Our ref: DOC19/531175  
Your ref: SSD-7308

**Subject: EES comments on Notice of exhibition – St Marys Intermodal, Forrester Road, St Marys – construction and operation of intermodal terminal and container park – SSD-7308**

**EES comments on Notice of Exhibition - St Marys Intermodal, Forrester Road, St Marys – construction and operation of intermodal terminal and container park - SSD-7308**

103 C

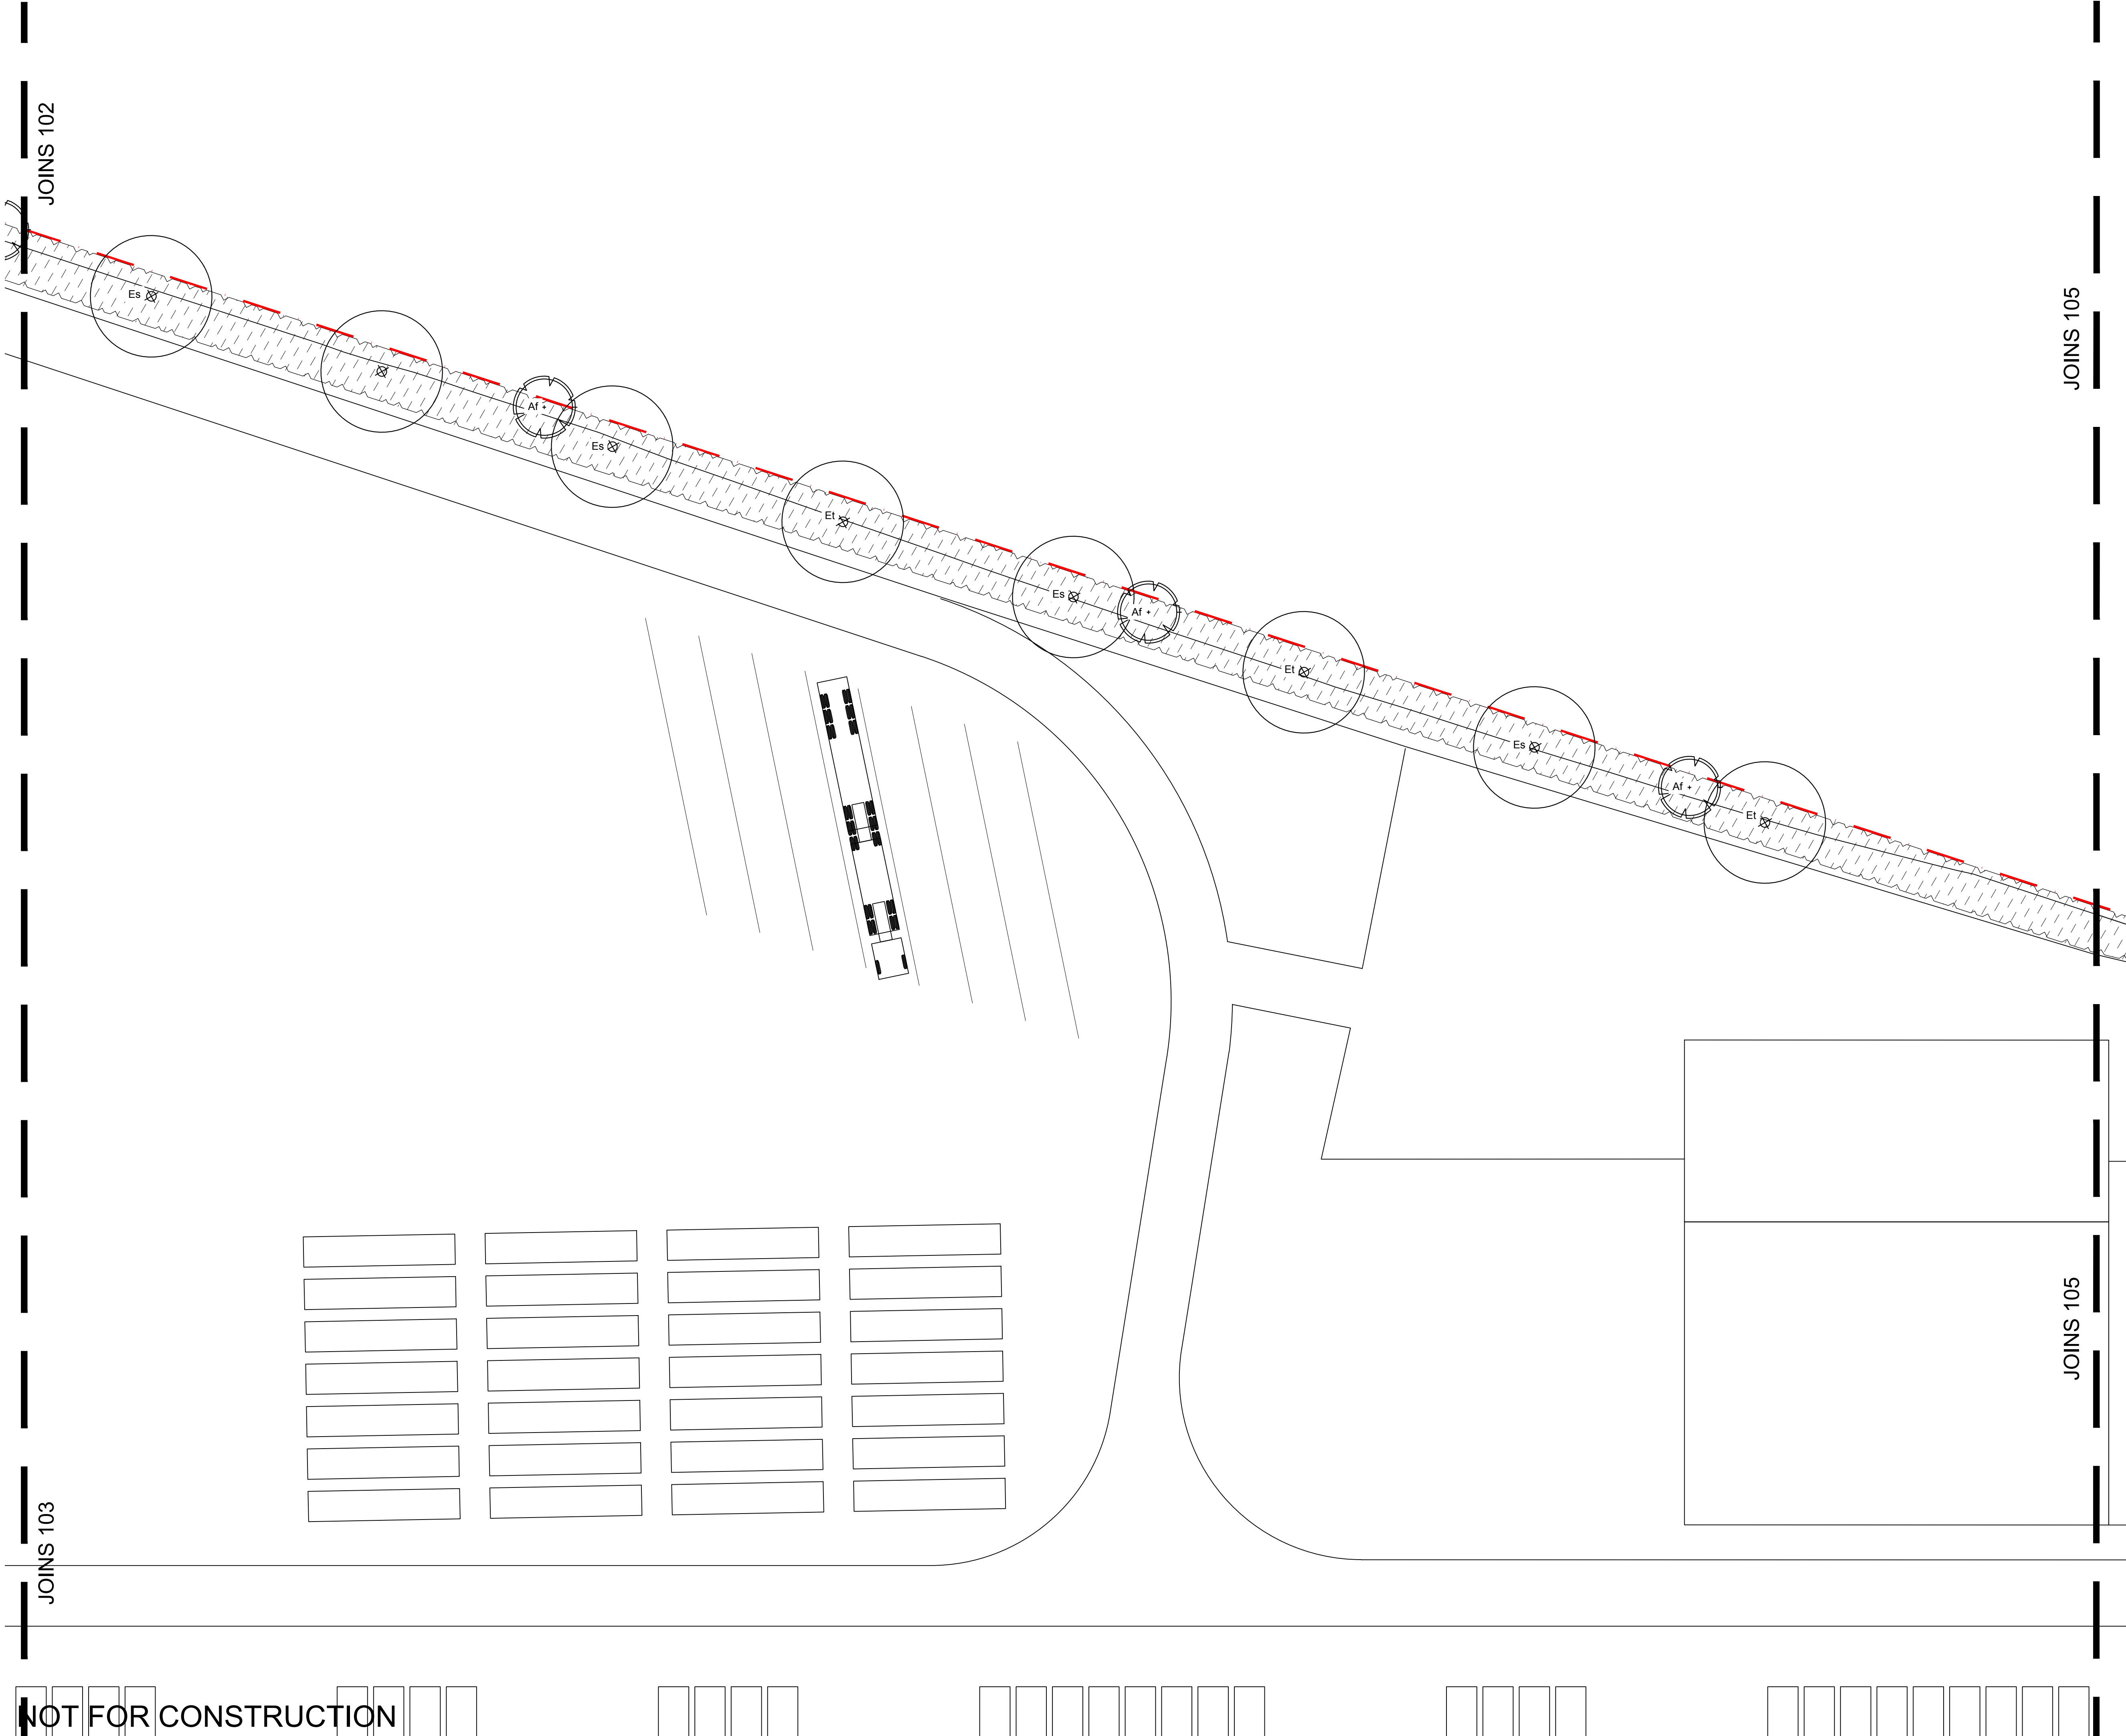
- Table 26 includes recommendation that a vegetation management plan is prepared to protect and enhance retained vegetation. This is supported by OEH, particularly given the areas of retained vegetation are so small, that without active management they are unlikely to persist in the long term. However, the species to be planted in these areas and adjacent to these areas should be appropriate for the vegetation type. The EIS states that "The landscape design has adopted endemic species from the Mitchell Landscapes. Hawkesbury-Nepean Channel to complement the existing native vegetation being retained onsite". OEH recommends that the species to be planted should be derived from species lists for the relevant Plant Community Type, using Figure 3 of the BDAR as a guide. Plants should be sourced from locally endemic provenance material.
